September 6, 2024

Re: **Responses to Comments** –
Harborview Heights – Technical Review 1
SP23-007

City of Marysville Community Development – Planning Division

HARBOR VIEW HEIGHTS
 SHORT PLAT
 NUMBER SP23-007

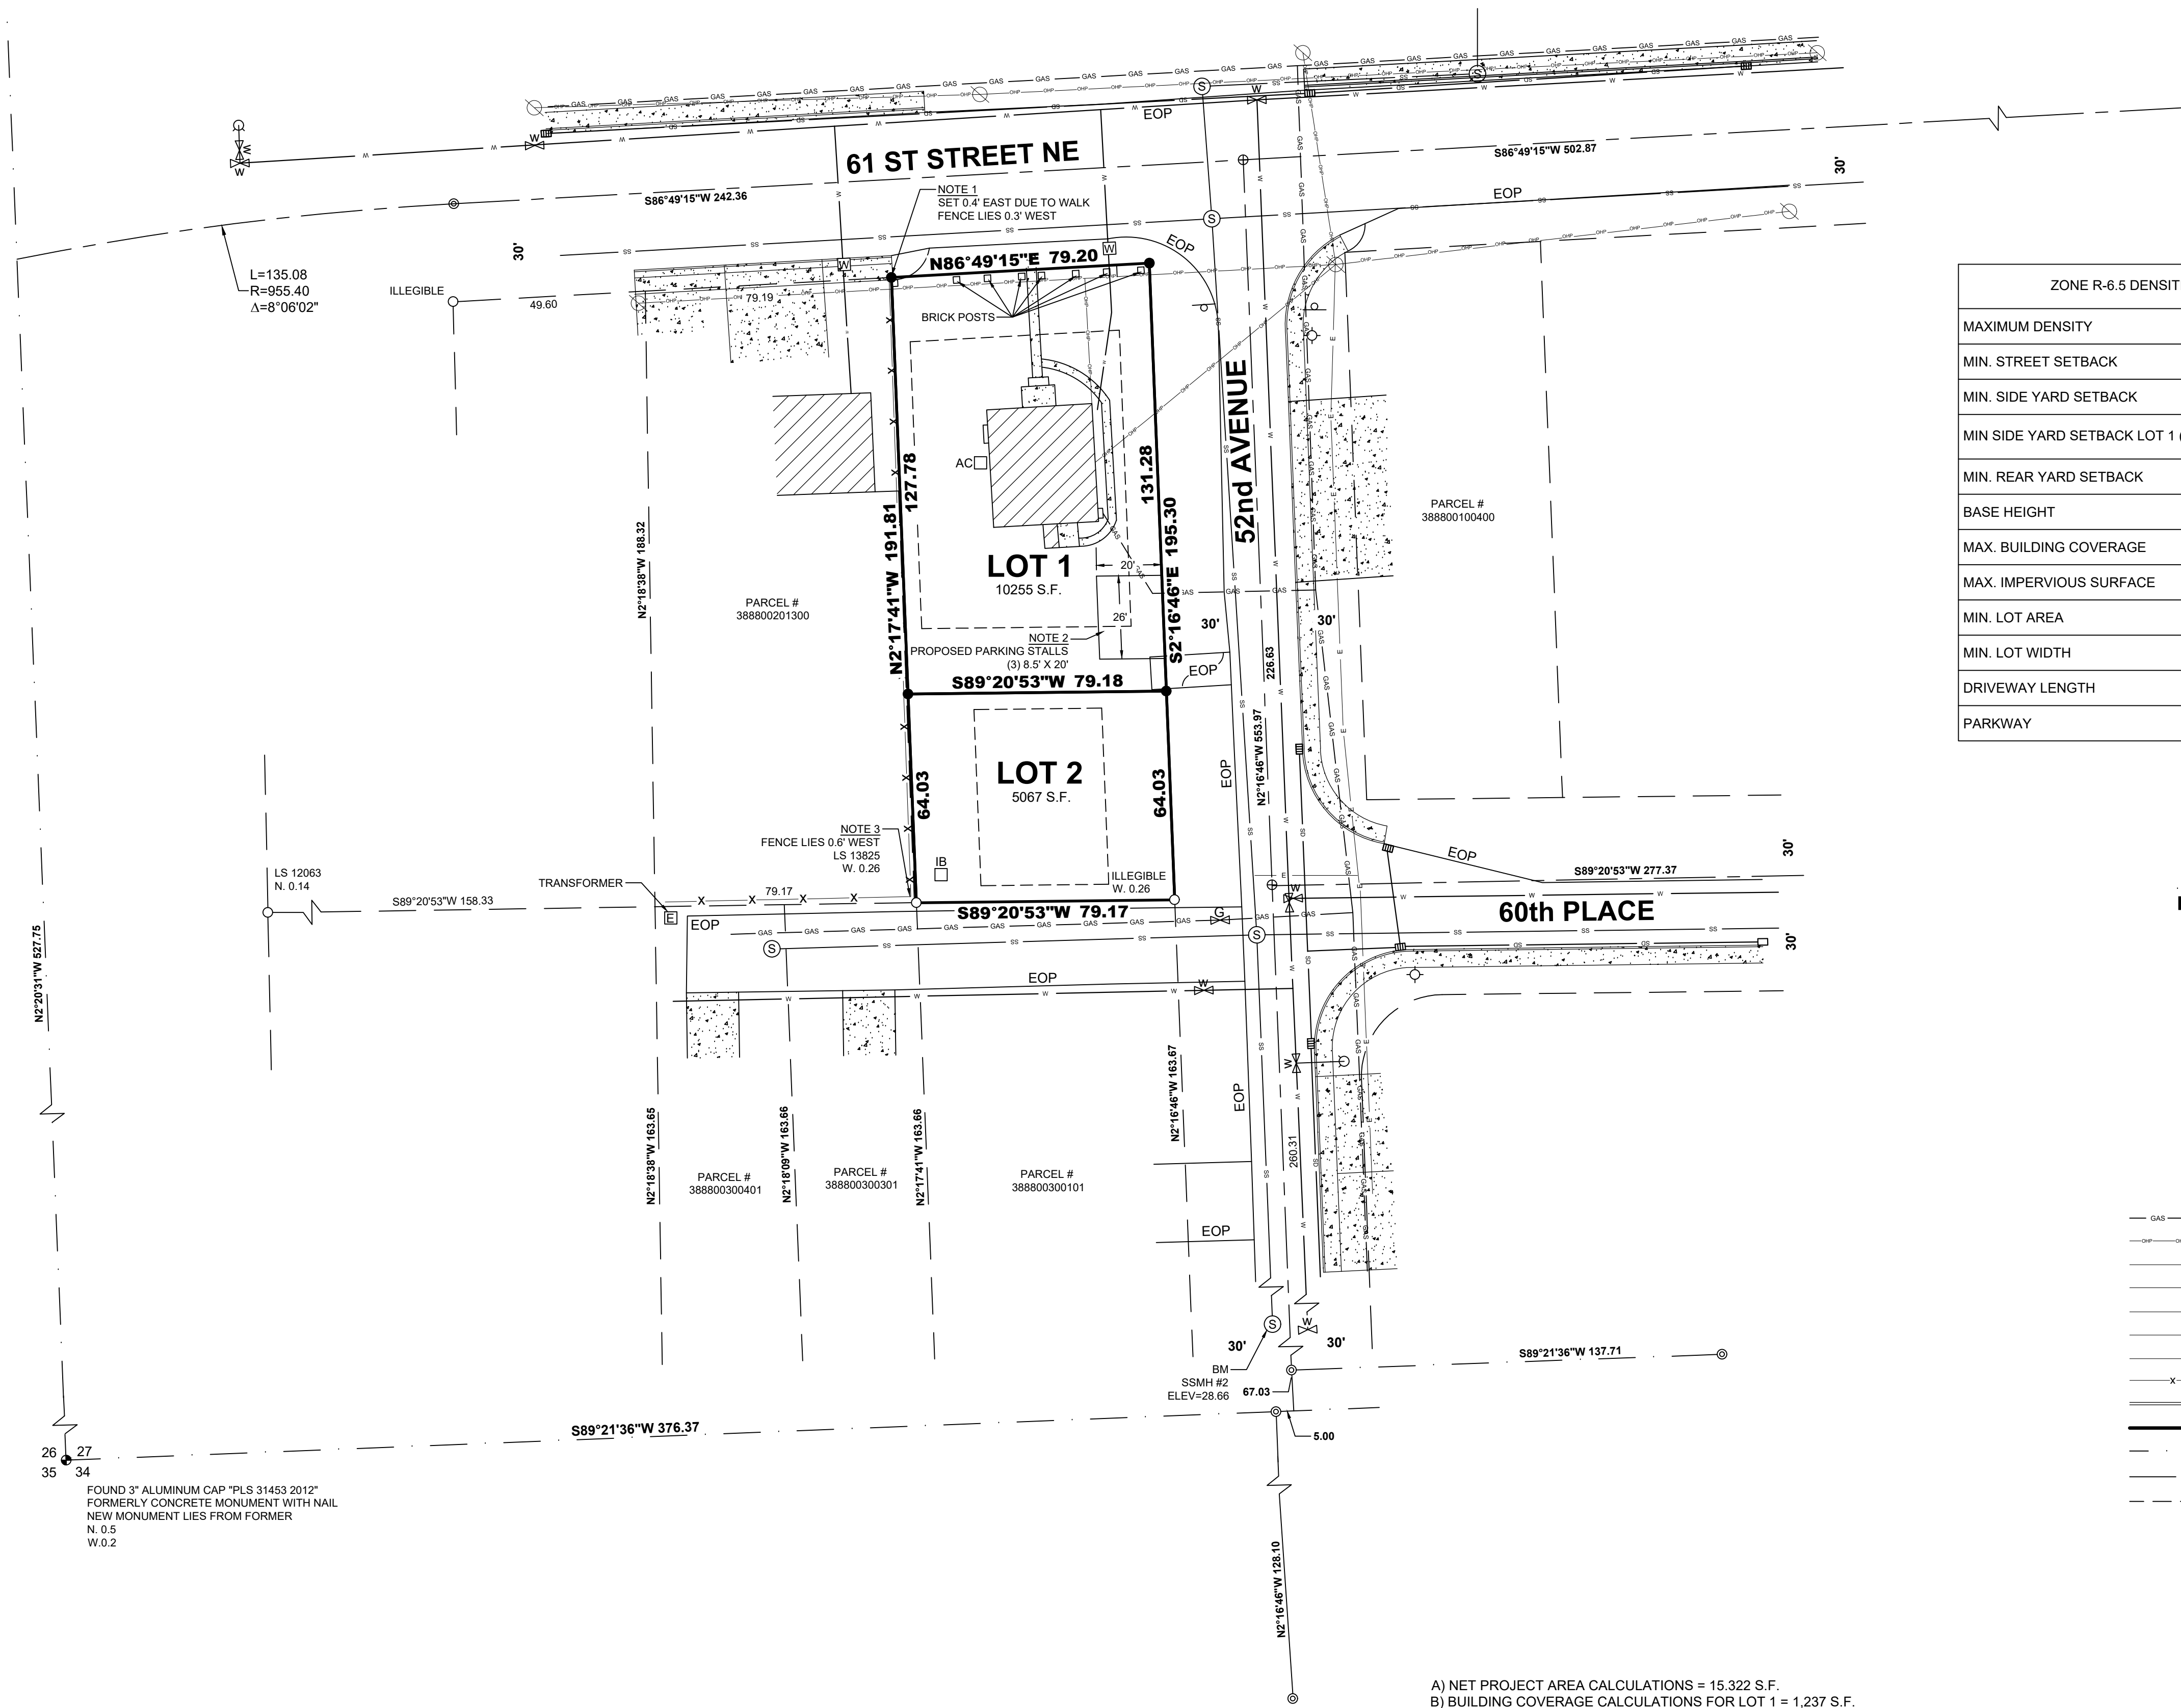
2. Show the following setback lines on the preliminary short plat map: a. Lot 1:

- i. Front yard 20ft
- ii. Rear yard 20ft
- iii. Side yard (52nd Ave) 10ft
- iv. Side yard (west) 5ft

b. Lot 2:

- i. Front yard 20ft
- ii. Rear yard 20ft
- iii. Side yards 5ft

3. Amend the preliminary short plat map, to include the following table:

Zone R-6.5 Densities and Dimension Standards (MMC 22C.010.080)	
Maximum Density	6.5 du/acre
Min. Street Setback	20 feet
Min. Side Yard Setback	5 feet
Min Side Yard Set Back Lot 1 (52 nd)	10 feet
Min. Rear Yard Setback	20 feet
Base height	30 feet
Max. building coverage	40%
Max. impervious surface	50%
Min. Lot area	5,000 SF

Min. Lot width	50 feet
Driveway length	20 feet
Parking	3 stalls per single-family dwelling

- 4. Amend the preliminary short plat map to include the following:
 - a. Net project area calculations (see definition in [MMC 22A.020.150](#))
 - b. Building Coverage calculations for lot 1
 - c. Impervious surface calculations for lot 1 (see definition in [MMC 22A.020.100](#))

[Setbacks are shown on the Plat Map.]

[Table has been included on the Plat Map.]

[Calculations have been included on the Plat Map.]
